WEST SUSSEX COUNTY COUNCIL CONSULTATION

TO:	Arun District Council FAO: Michael Eastham
FROM:	Highways, WSCC
DATE:	19/04/2021
LOCATION:	Land at Angels Nursery, Yapton Road, Barnham, PO22 0AY
SUBJECT:	BN/38/21/PL Construction of feature entrance wall set back from access to approved residential development.
DATE OF SITE VISIT:	N/A
RECOMMENDATION:	Advice
S106 CONTRIBUTION TOTAL:	£N/A

| Drawing Title  |    | SITE_ENTRANCE_FEATURE_WALL_LAYOUT |            |

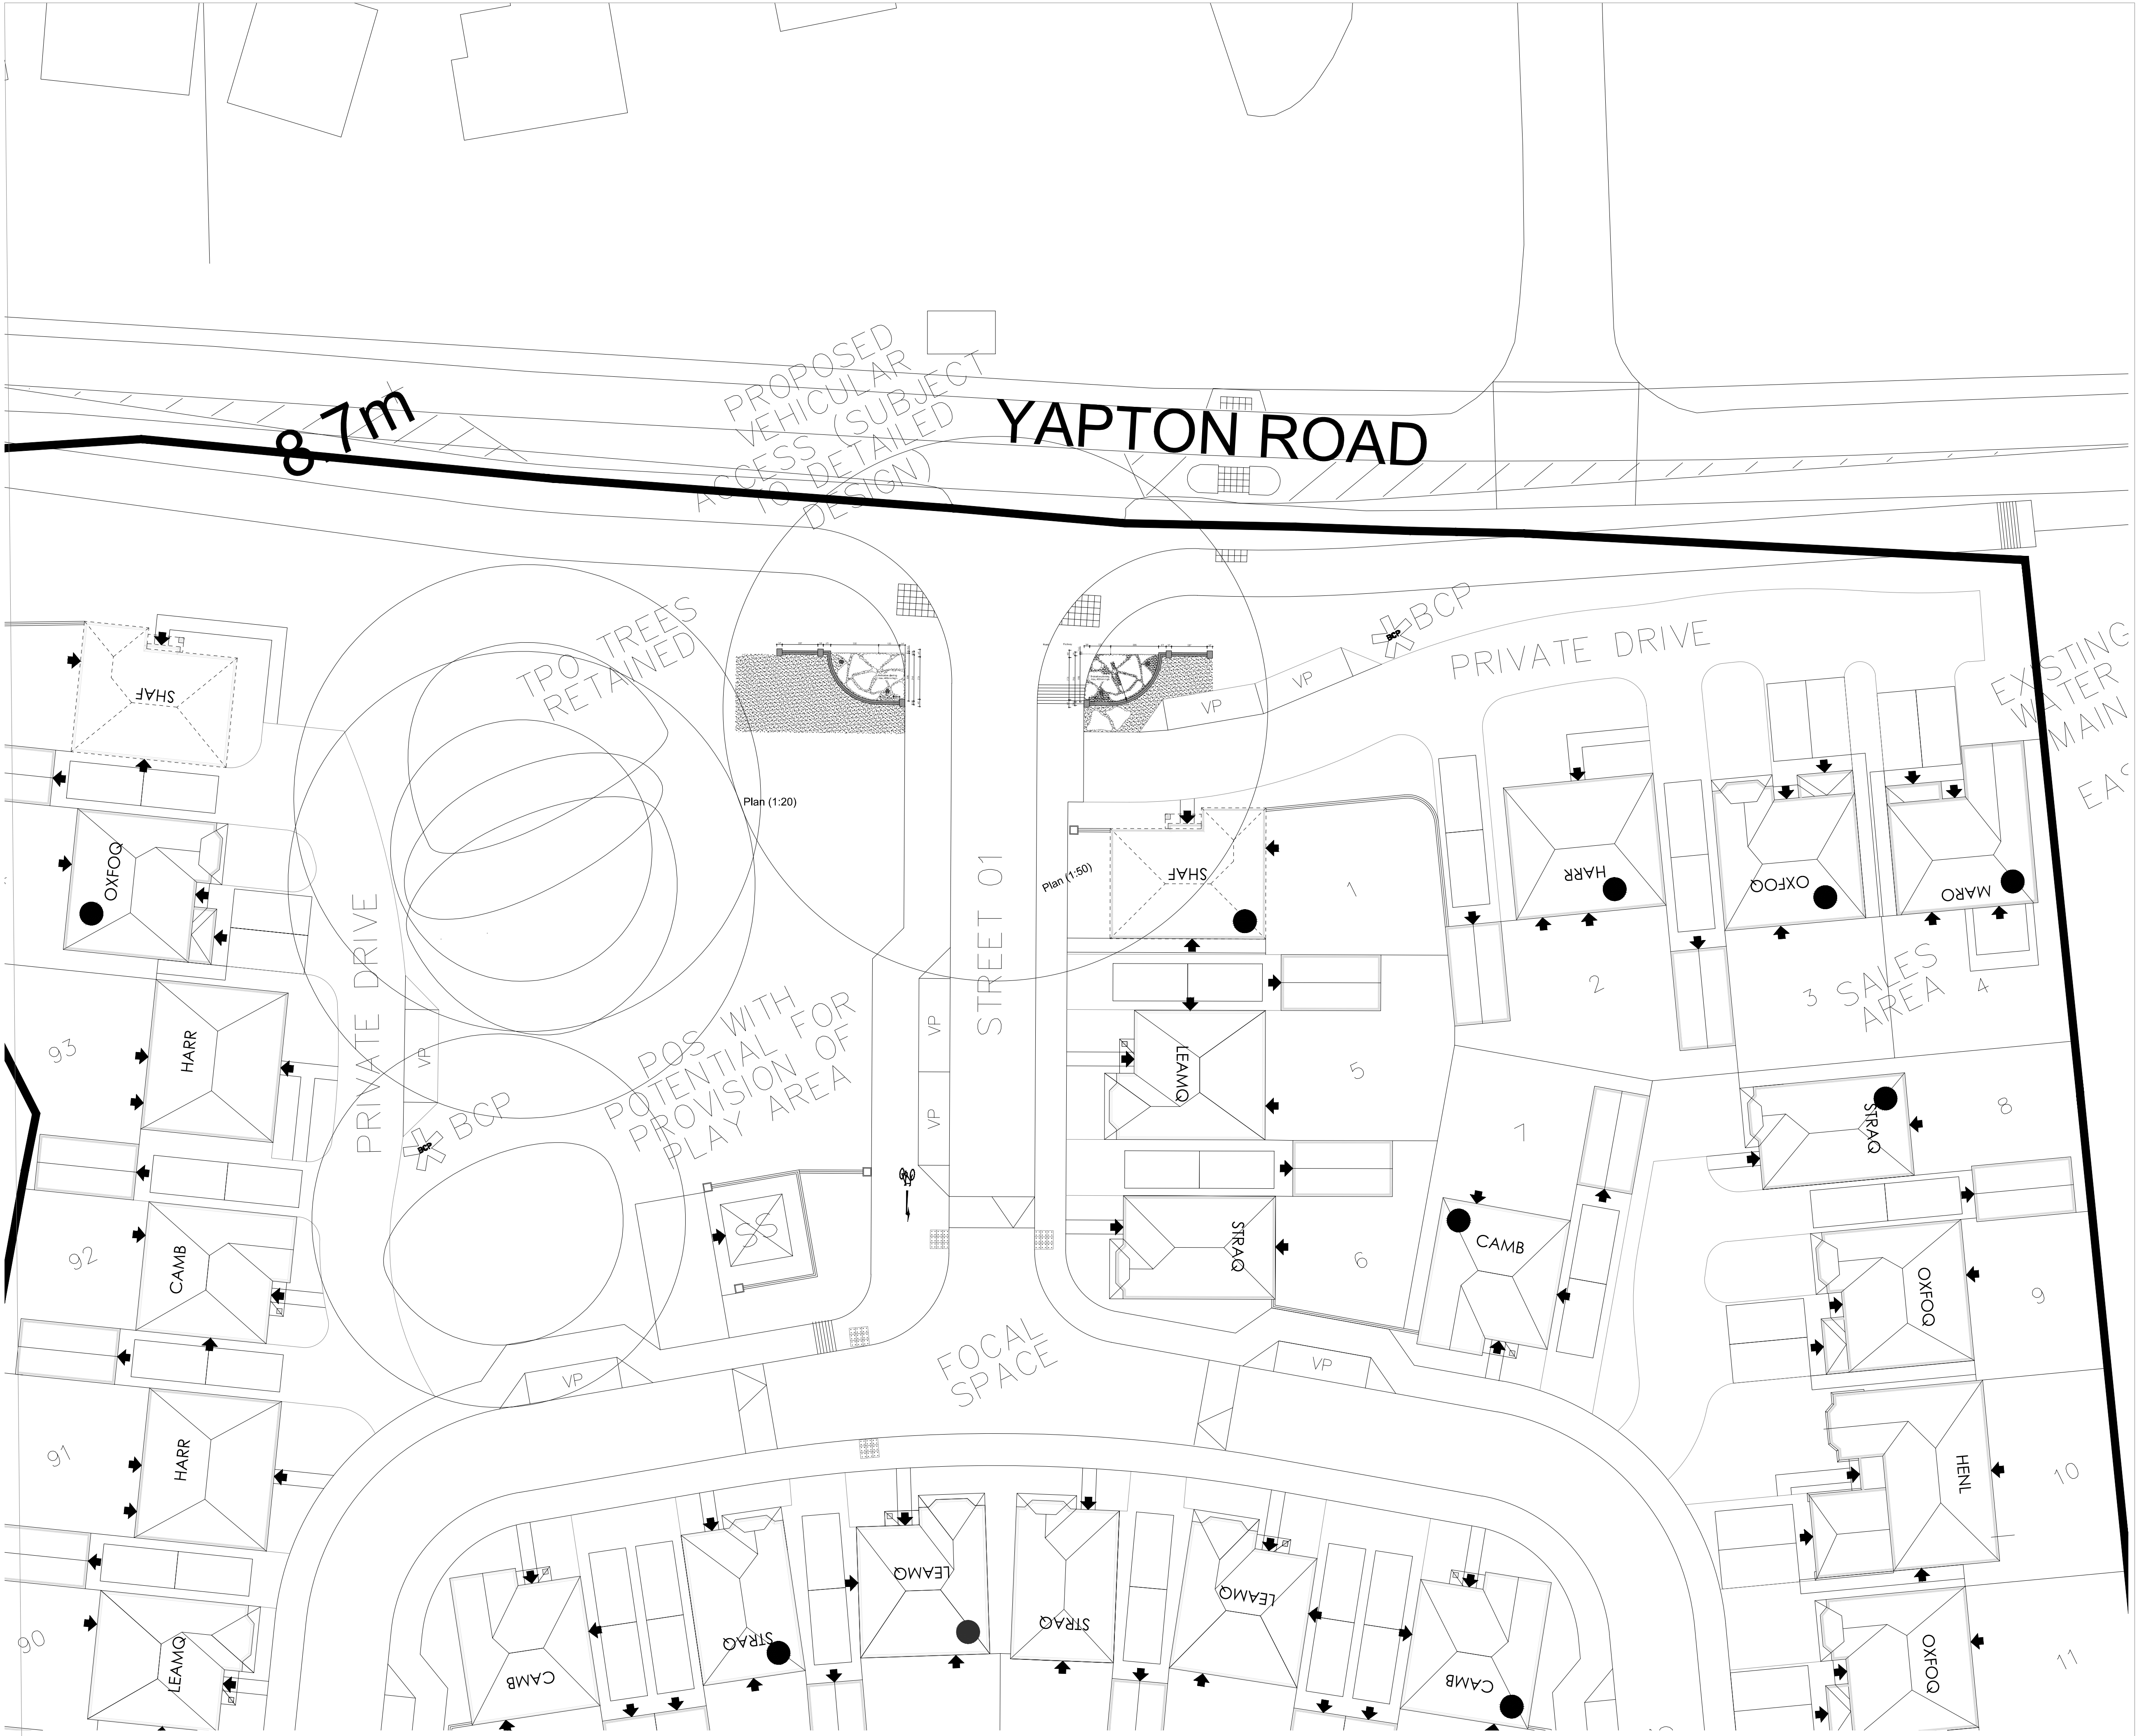
The proposed feature entrance wall will be set back 8m from the edge of the carriageway, consisting of 1.2m high walls with 1.5m high piers. From inspection of the plans and local mapping, the proposed wall will be situated outside of highway boundary and is not anticipated to obstruct vehicular visibility for those using the access on Yapton Road.
